Consultation Response from KC, Highways Development Management
2020/91611 92, New North Road, Edgerton, Huddersfield, HD1 5QP
Change of use from mixed commercial/residential use to fully commercial (B1 office), demolition of the rear toilet block and associated works (Within a Conservation Area)
Date Responded: 07/07/20 Responding Officer: J Turner Responding Ref: K5-5SE/16

PROJECT TITLE:	92 New North Road Huddersfield
DRAWING TITLE:	Proposed Carpark
DRAWN:	DRW
DATE:	07/01/2020
SCALE:	1:200
DRAWING No:	19.064/DRW/006
REVISION:	
ALL RIGHTS RESERVED, DRAWING NOT TO BE REPRODUCED WITHOUT PERMISSION. DO NOT SCALE

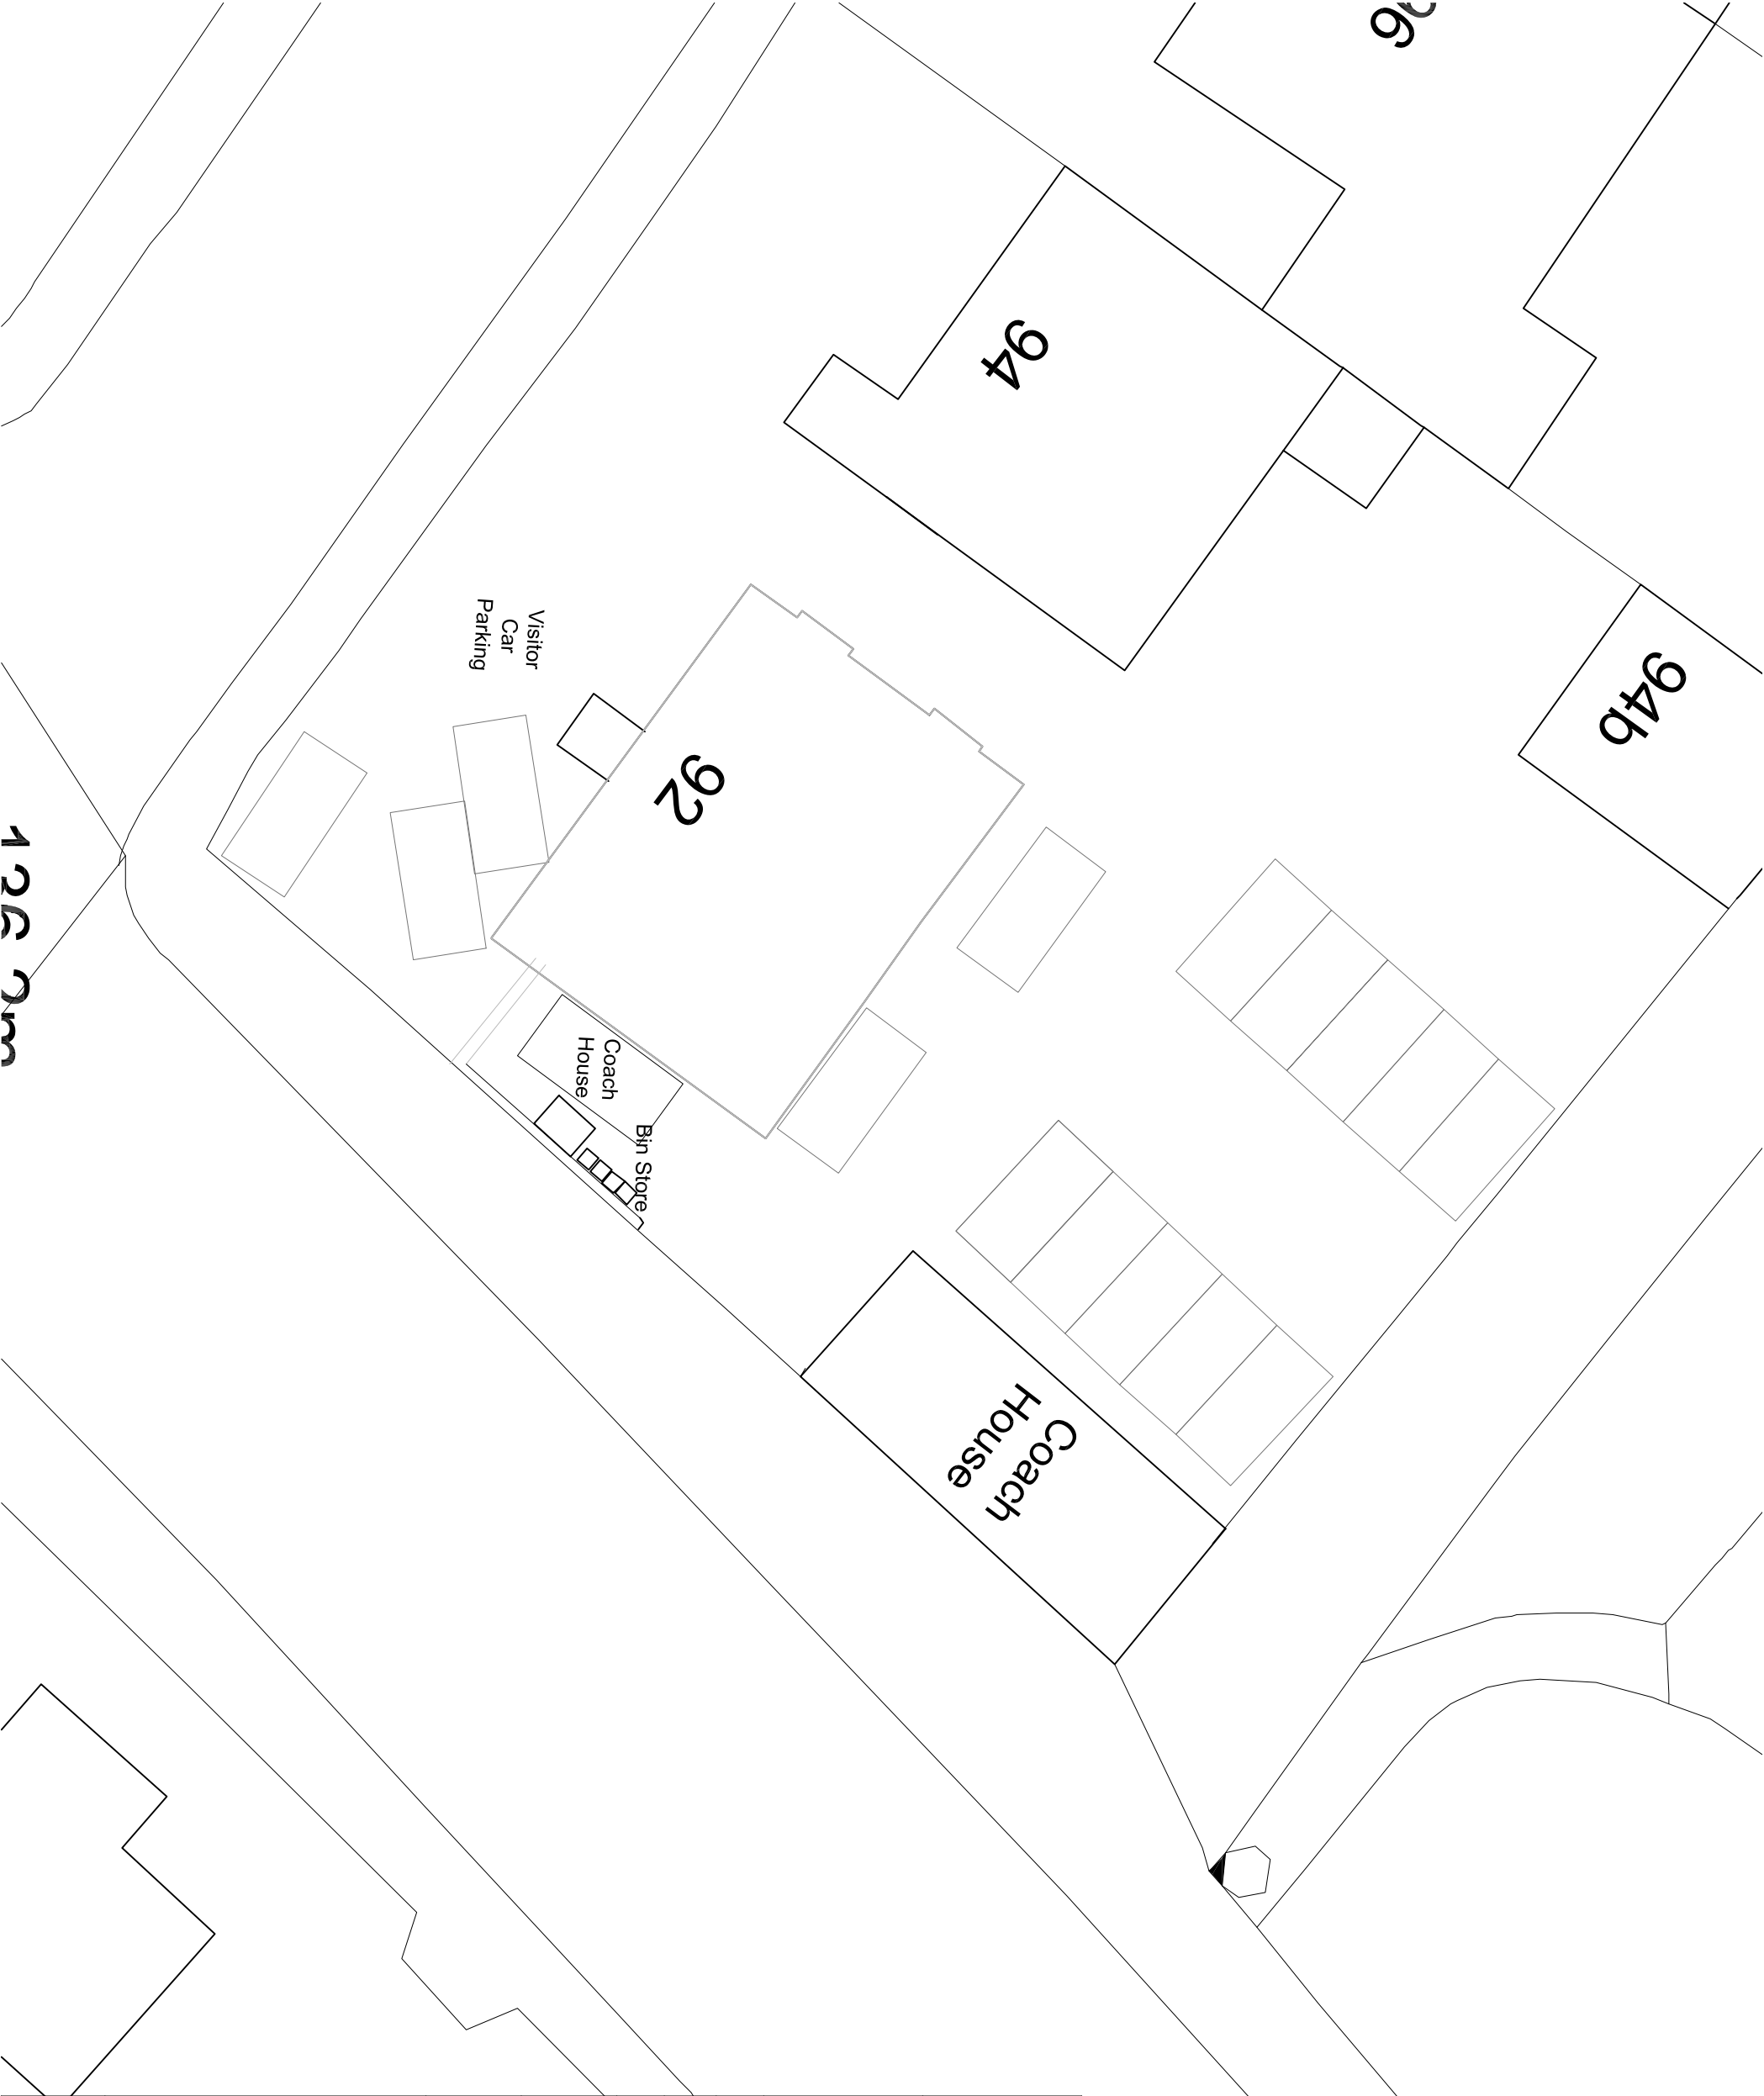
The proposed car park is almost identical to the one approved for the mixed use development, and detailed swept-path analysis of vehicles accessing and exiting the site in a forward gear from various parking spaces was provided at this time.

To change the use to entirely office space is unlikely to significantly intensify the vehicle movements on the site, and the scheme is therefore acceptable from a highways perspective.

Please repeat the waste storage condition from the previous permission in this decision notice:

The areas shown on the approved site plans for the storage of wastes shall be retained at all times and kept clear of all obstructions to its use.
